Subject: Written Representation Submission for
Deadline 1 – East Pye Solar (EN0110014)

- Project Name: East Pye Solar
- Project Reference: EN0110014
- Submission Content: Full Written
Representation containing an integrated
Executive Summary, Methodological
Disclosure, primary evidence exhibits, and
specific cross-examination questions
regarding parameter contradictions, battery
storage queue status limitations, and

SECTION 1: SITE ONE (THE CENTRAL TRANSMISSION & BESS COMPLEX)

- Sites
- Proposed BESS
- National Grid Substation Site and Point of Connection
- National Grid Substation Option 2 Site and Point of Connection
- Cable Route Corridor
- 1A Site/Sub Site Number
- CRC1 Cable Route Corridor Number

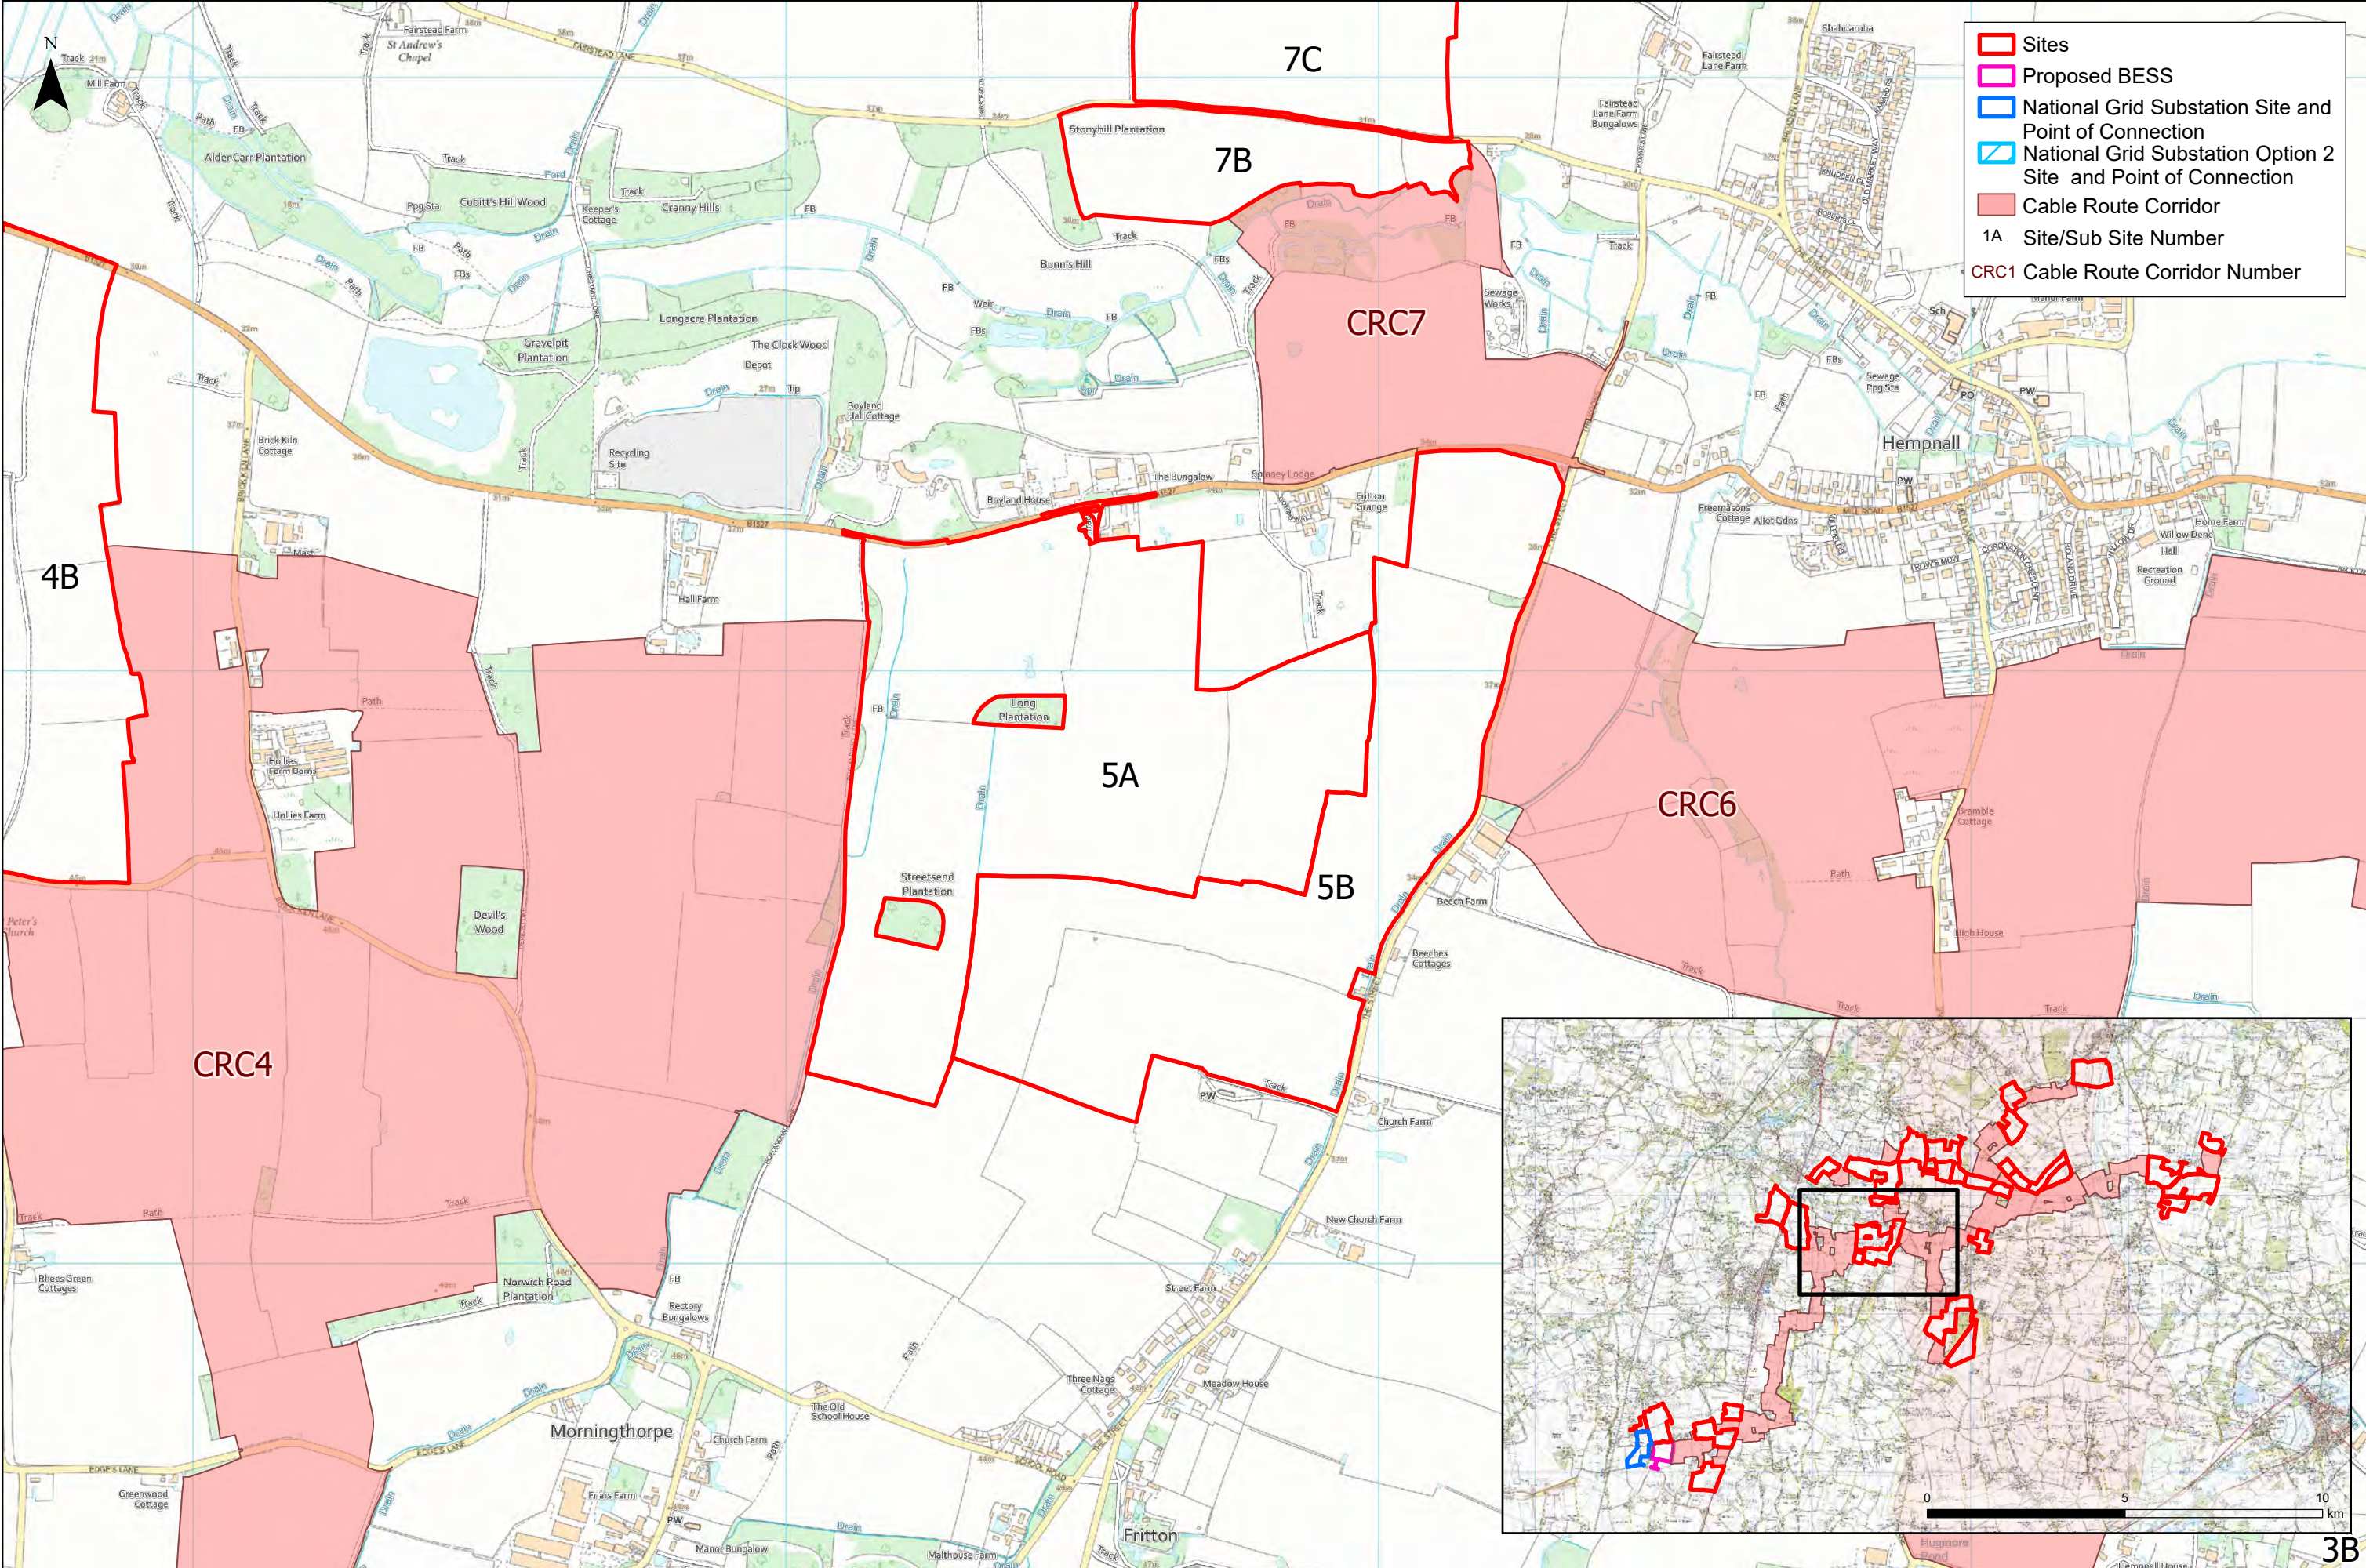
A major contradiction exists between the submitted graphic plans, the public consultation promises, and the accompanying written text. The Applicant's framework explicitly stated that the development would be limited to a maximum parameters of three 132 kV substations and three 400 kV substations

across the entire project. However, the site plans demarcate three distinct 400 kV voltage class substations within the concentrated Site One compound alone, while a fourth 400 kV substation footprint is explicitly drawn on the master maps at Site 7 near Saxlingham Green. Component heights track up to a maximum parameter of 15 metres. Furthermore, specific hardware models remain uncommitted until post-consent procurement, meaning equipment options produce divergent acoustic signatures near residential boundaries. The Applicant's environmental noise statement relies on generalized acoustic models tailored exclusively to a neurotypical baseline, omitting any technical assessment for the neurodivergent baseline of the host community. For individuals with neurodivergent profiles or sensory processing differences, un-filterable low-frequency industrial noise represents an

- Question to the Applicant 3: "The Applicant's consultation literature explicitly stated that the development parameters would be structurally capped at a maximum of three 400 kV substations. Given that the submitted master layout maps clearly demarcate three 400 kV substations within the concentrated Site One compound alone, and a fourth 400 kV substation footprint drawn at Site 7 near Saxlingham Green, will

own maximum promised infrastructure caps on the plans, and clarify exactly how many individual 400 kV substations are to be constructed under this DCO?"
